Sent: 23 December 2011 14:37
To: Planning
Subject: Planning application N6/2011/2683/AD - 17-19 Howardsgate

Location
17-19 Howardsgate
Welwyn Garden City

Application type
Advertisement Consent

Proposal
Installation of 1 x fascia sign, 1 x projecting sign and 2 x window vinyls

DRAWING TITLE WELWYN GARDEN CITY POST OFFICE 17 HOWARDGATE WELWYN GARDEN CITY HERTS AL8 6AL		
SCALE 1:100	DRAWING No KL- 060610 - SF	DATE 06/05/11
DRAWN kevin.lear@costcutter.com		REVISIONS SF
 HARVEST MILLS, COMMON ROAD, DUNNINGTON, YORK. YO19 5RY TELEPHONE: 01904 488663 FAX 01904 489828

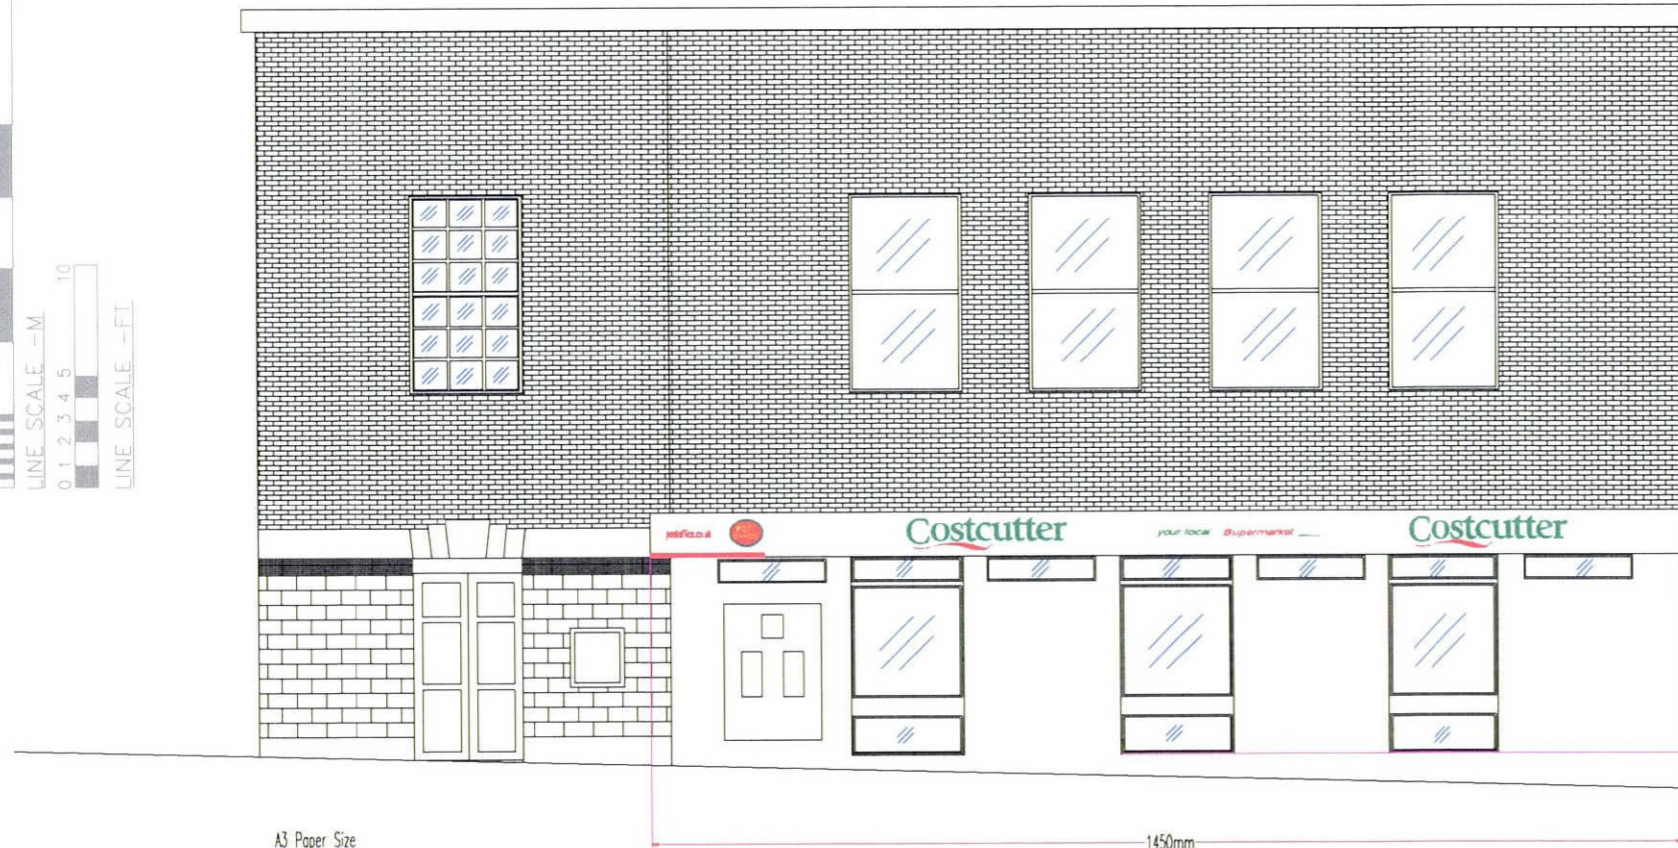
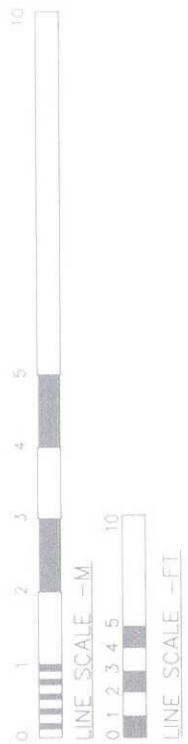
- 1. The intensity of illumination shall be controlled at a level that is within the limit recommended by the Institution of Lighting Engineers in the publication "Brightness of illuminated Advertisements" ILE Technical Report No 5.

COMMENTS: The proposed signage as shown on drawing KL-06-0610-SF has no implication on highway safety. The height above the footway and clearance to the edge of the kerb as shown meet the requirements of the Highway Authority and would not affect the free passage of pedestrians.
